AT 22 Cumberland Ave L 014 B004001

Permit No: 05-1416	Issue Date: PERMIT ISSUED	CBL: 014 B004001
-----------------------	-------------------------------------	---------------------

Proposed Use: Multi Family-Three Unit	Proposed Project Description: Interior renovations to apartment #2
---	--

New Floor Plan of 22 Cumberland
Apt #2.

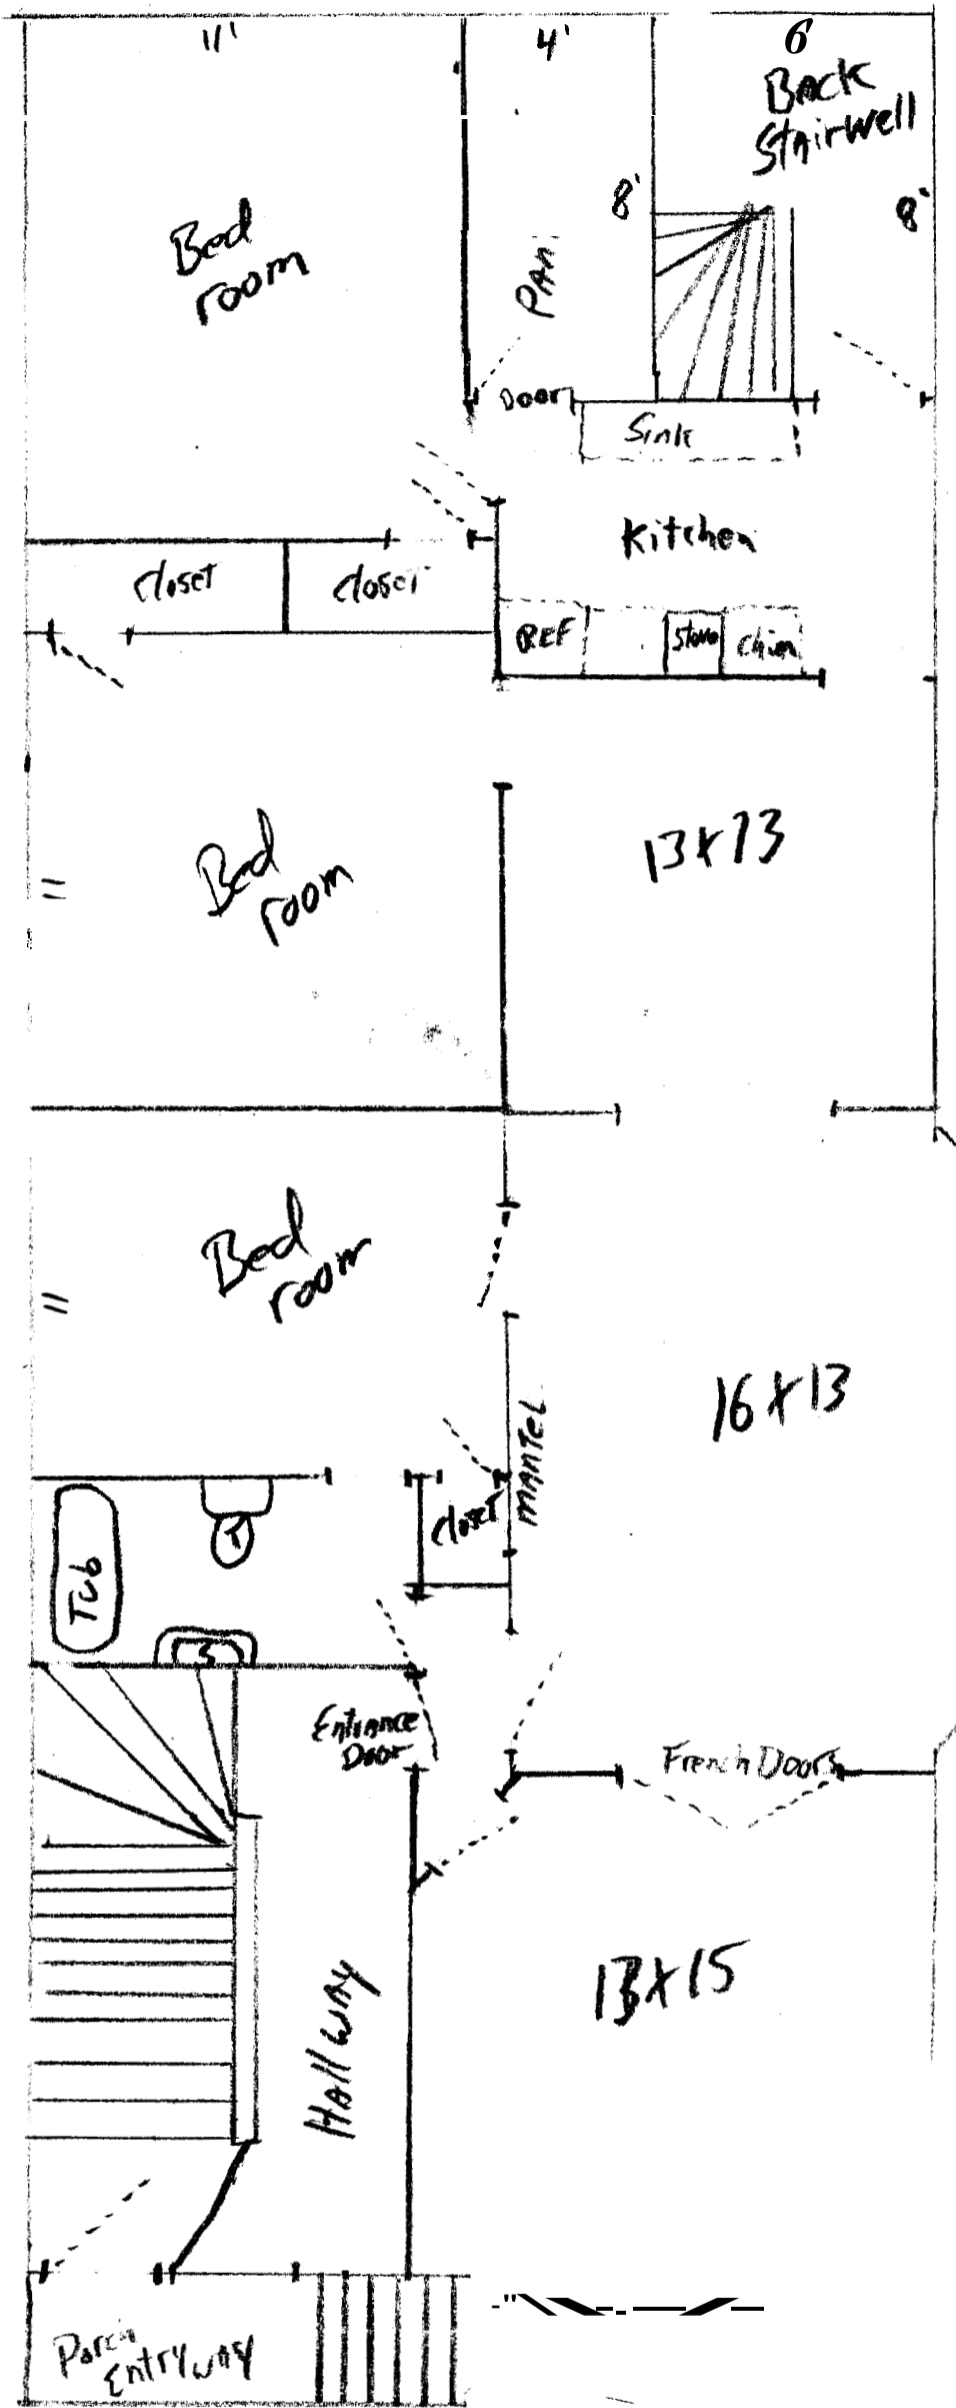
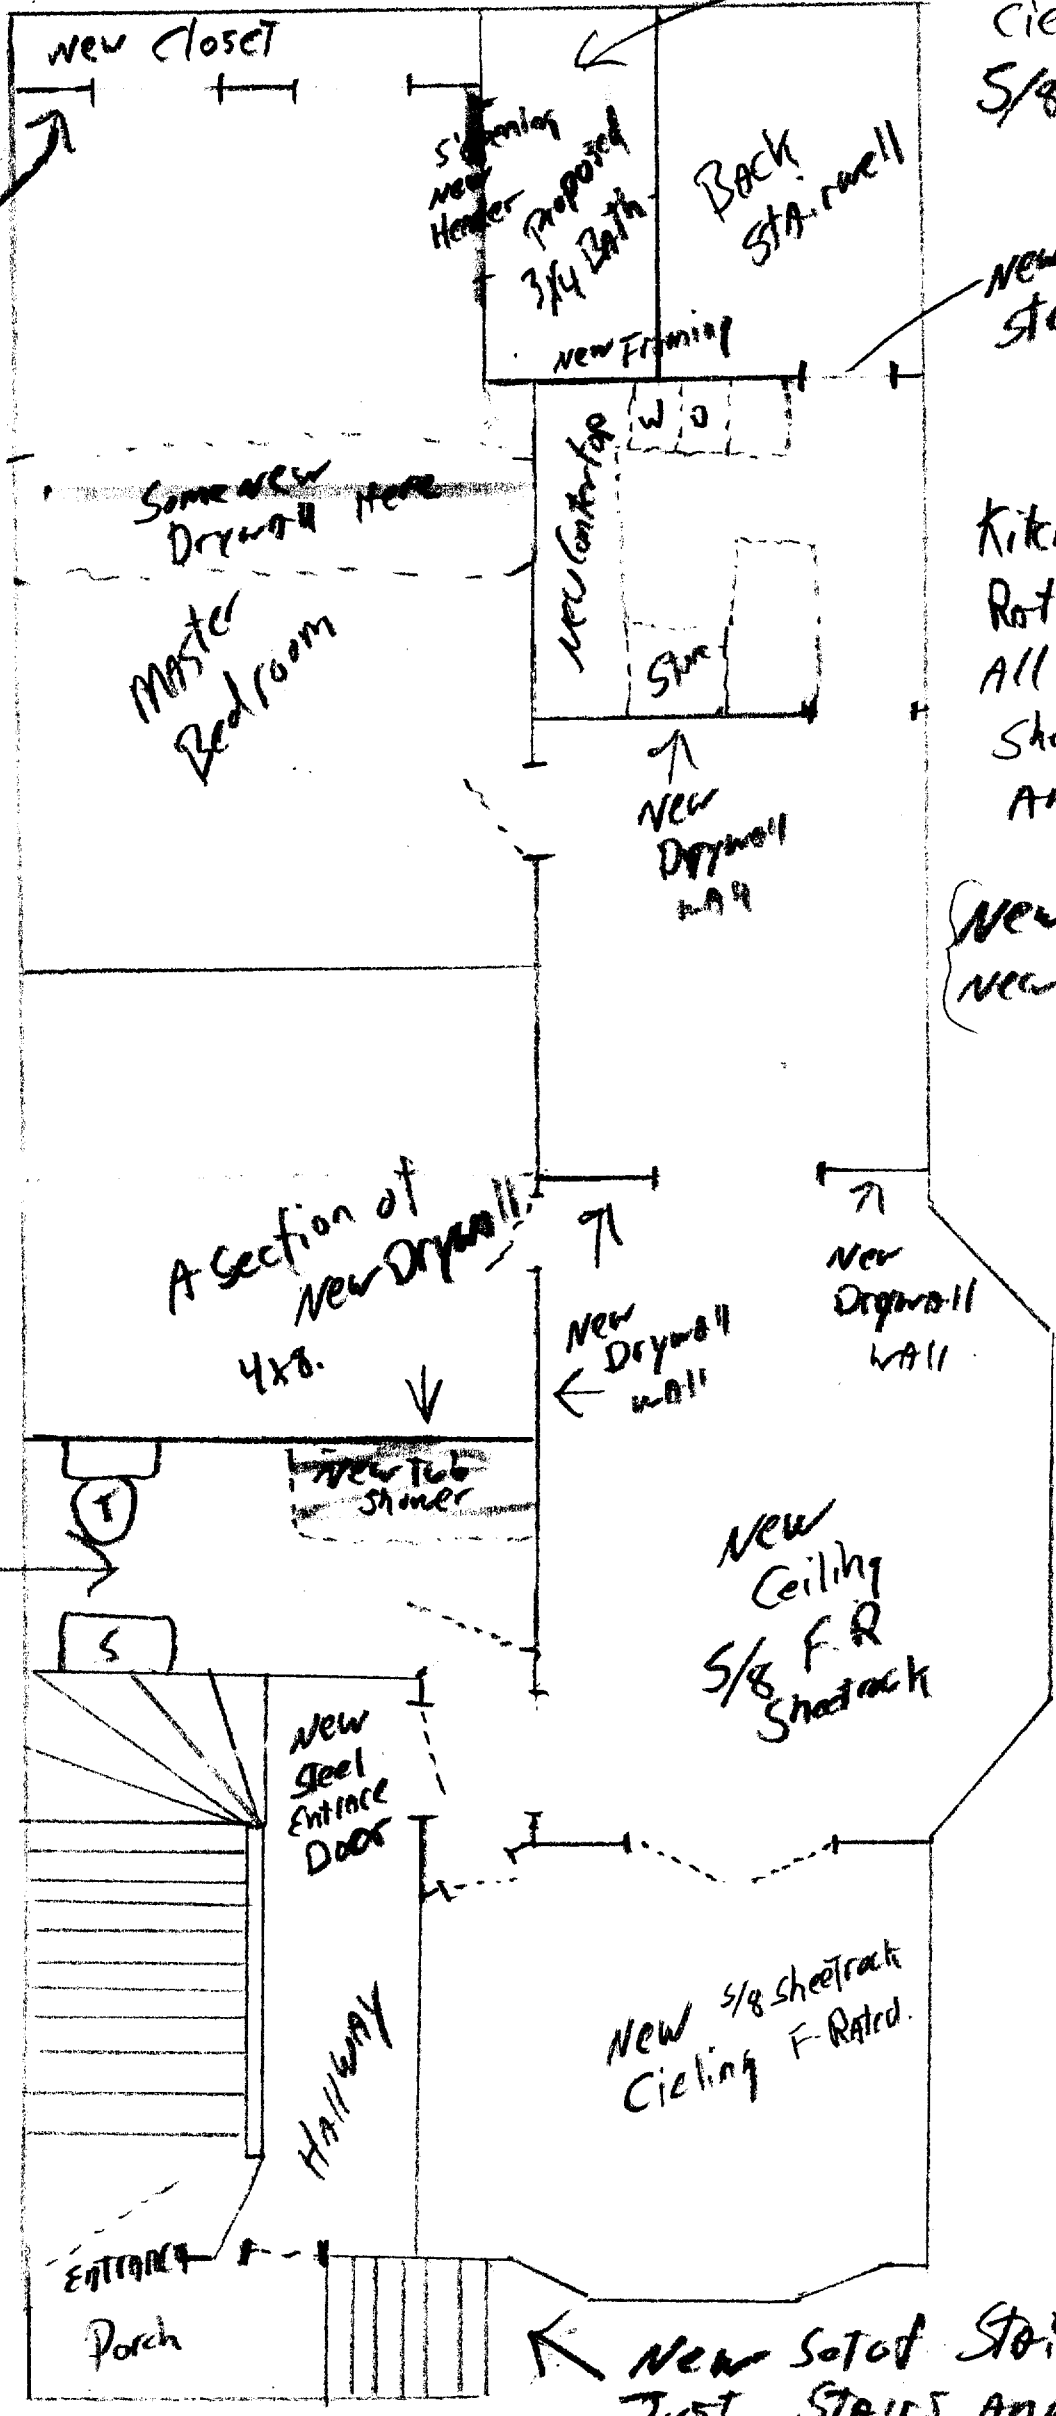
- 1) This permit does not contemplate and exterior stair or step replacement, separate permits are required for this work.
- 2) All renovated ceilings and wallse separating units from stairways. must have a one hour fire resistance rating with an STC of 50. Newly installed doors from units into common halls or stairs must be 45 Minute doiors and Frames. Please be advised that the Fire Code is potentially more restrictive and will require one hour doors. If this is the case the one hour door must be installed.

10/17/2005-mjn: need stair details, fire separation details, left message w/ owner NO STAIRS AS PART OF THIS PERMIT

11/4/2005-mjn: treads , riser, and guards don't meet code, may be zoning implications if there is expansion. Left message with Dale Carlson
